Planning Application Ref: AW/28/19/PL

Location: Rear of 276 Aldwick Road, Aldwick, PO21 3QH

Description of works: Erection of 1 No. dwelling & associated works.

Tree Officer / Parks and Greenspace Team

client			
Acuba Developments			
project			
Land to Rear of 276 Aldwick Road Bognor Regis			
title			
Location & Block Plan			
date	scale @ A3	drawn	chkd
Jan 2019	As shown	KWF	MRL
project no.	drawing no.	rev	
1814	P02	-

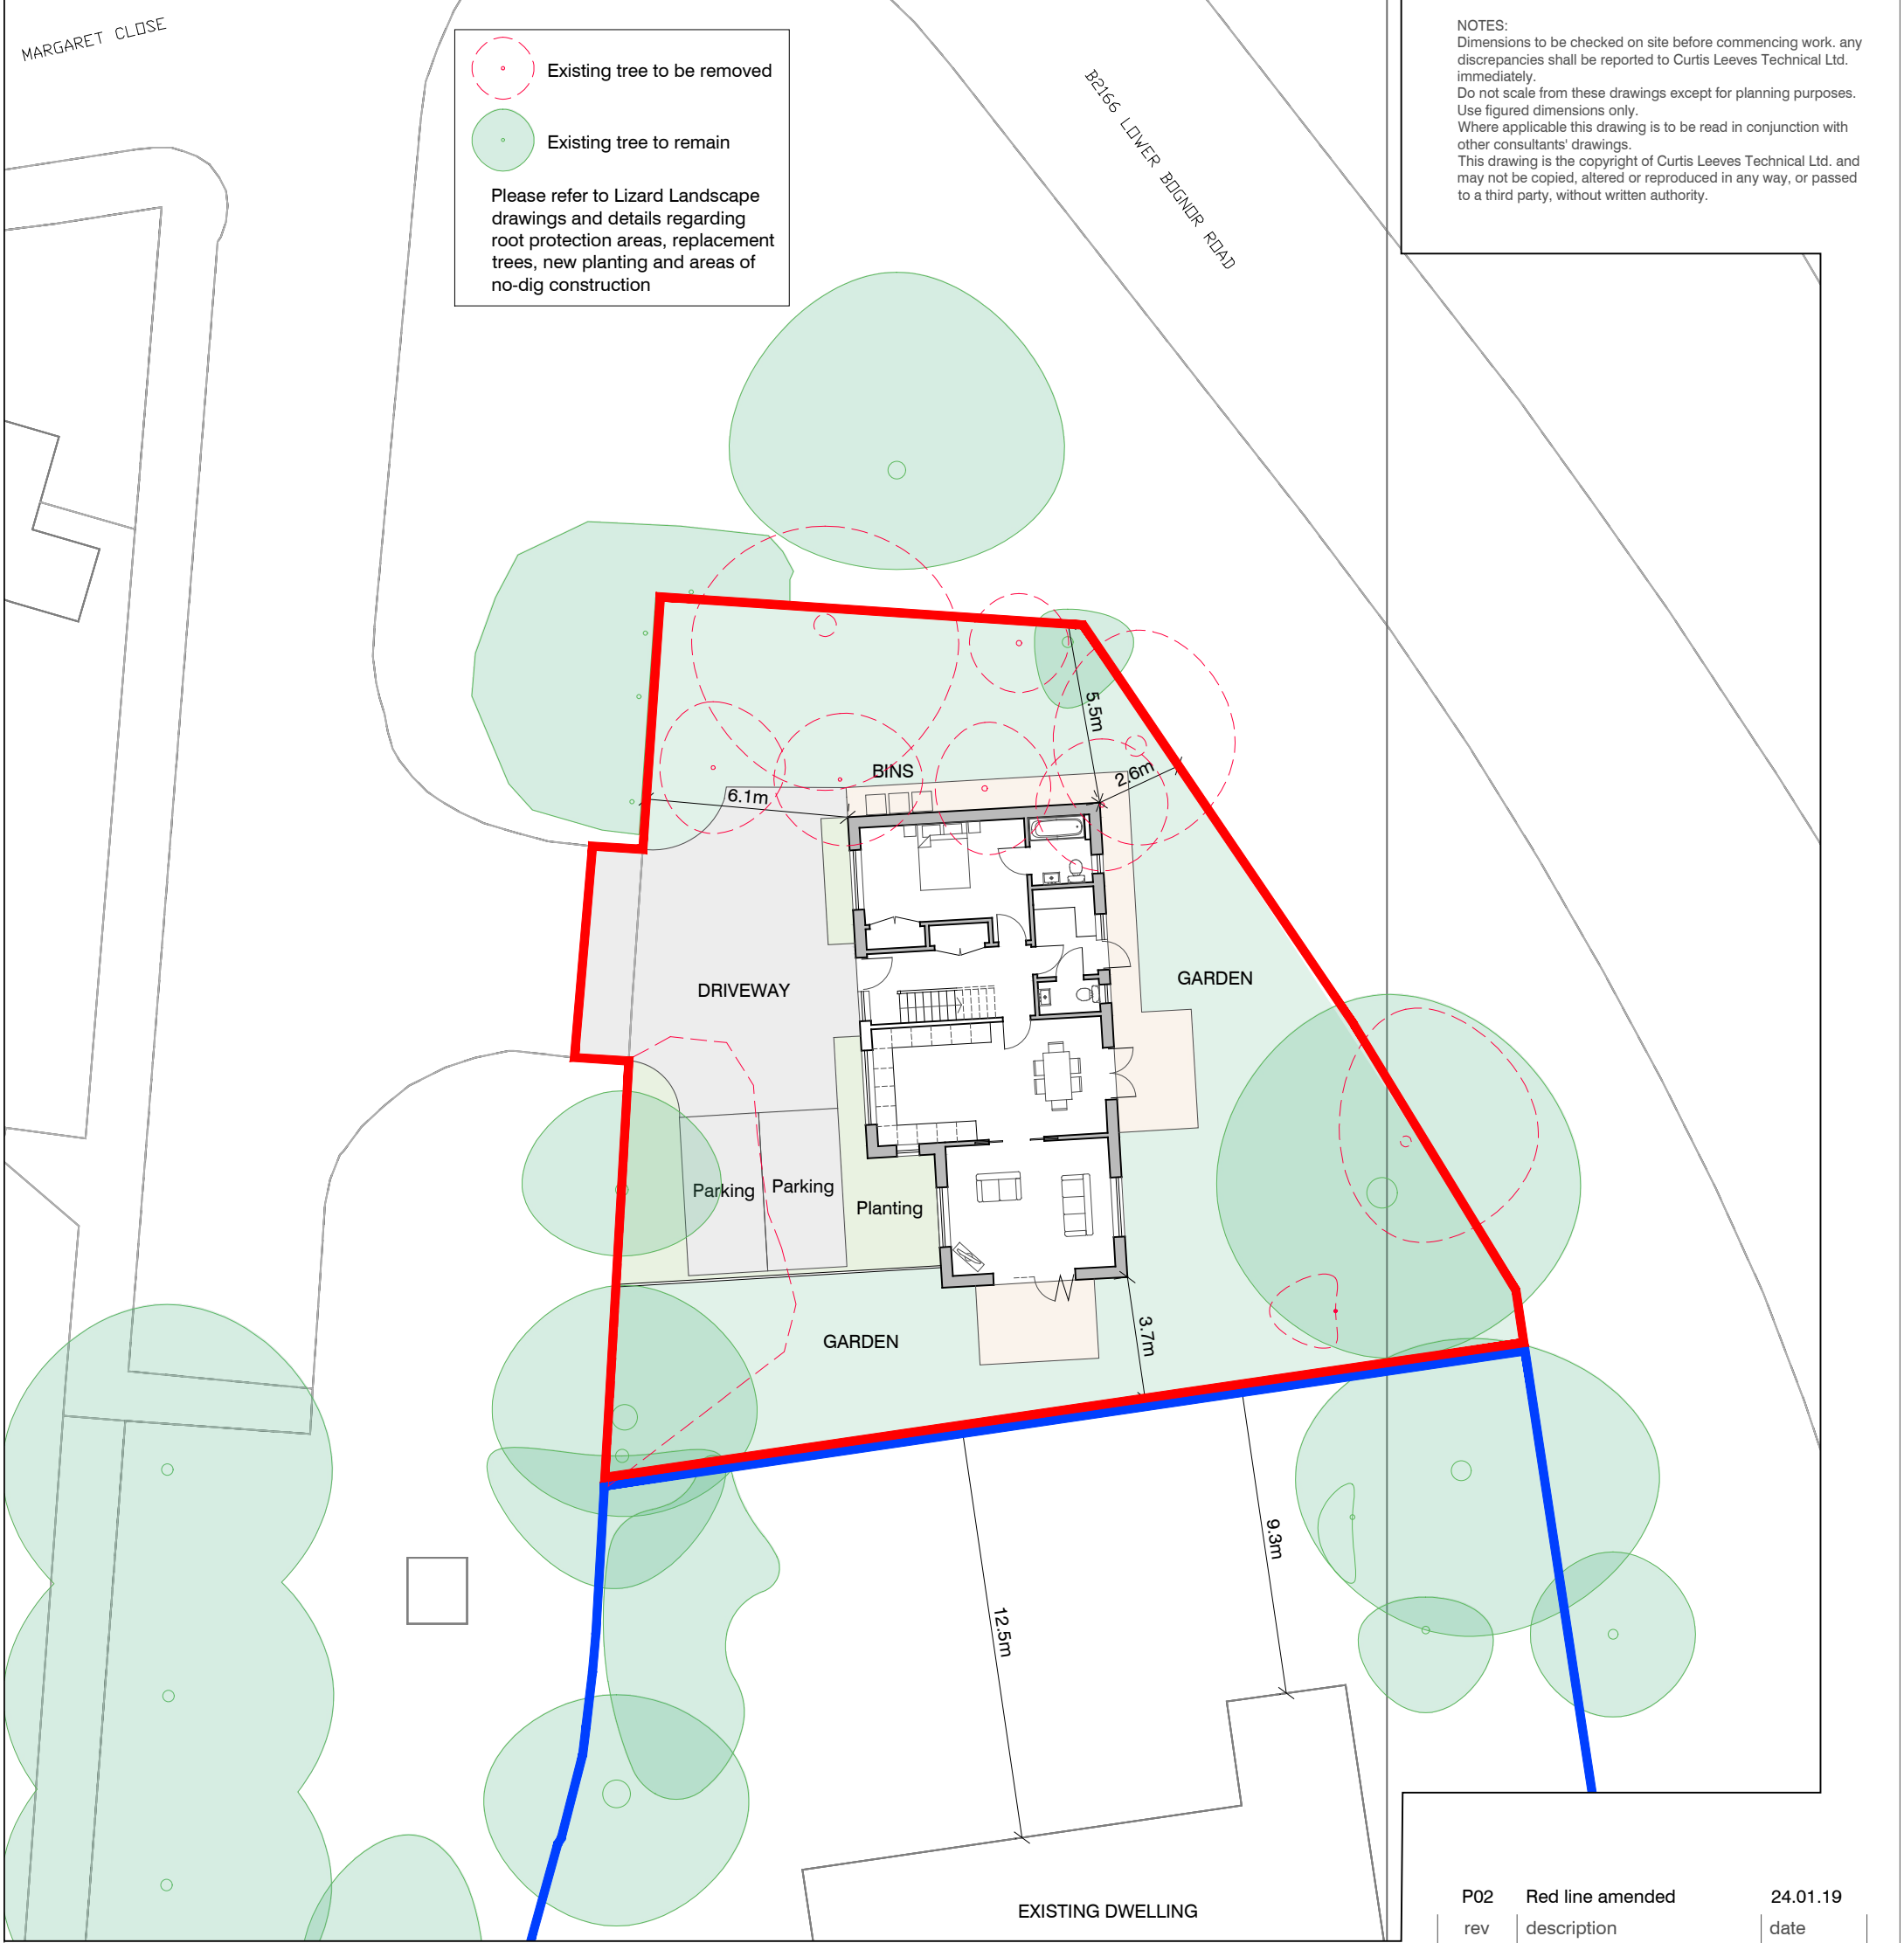
- The relationship between ground levels at the proposed vehicle access and driveway with both adjacent areas of 'no-dig construction' has not been described in detail or shown on any cross-section drawing. The viability of this critical element of the development proposal must be revealed via civil engineering exercise, so we can be sure those trees retained will not suffer damage and that finished ground levels in a broader context will be acceptable.

- Drainage and service-runs in and out of site have not been shown and so there remains a high probability of further root protection area incursion.
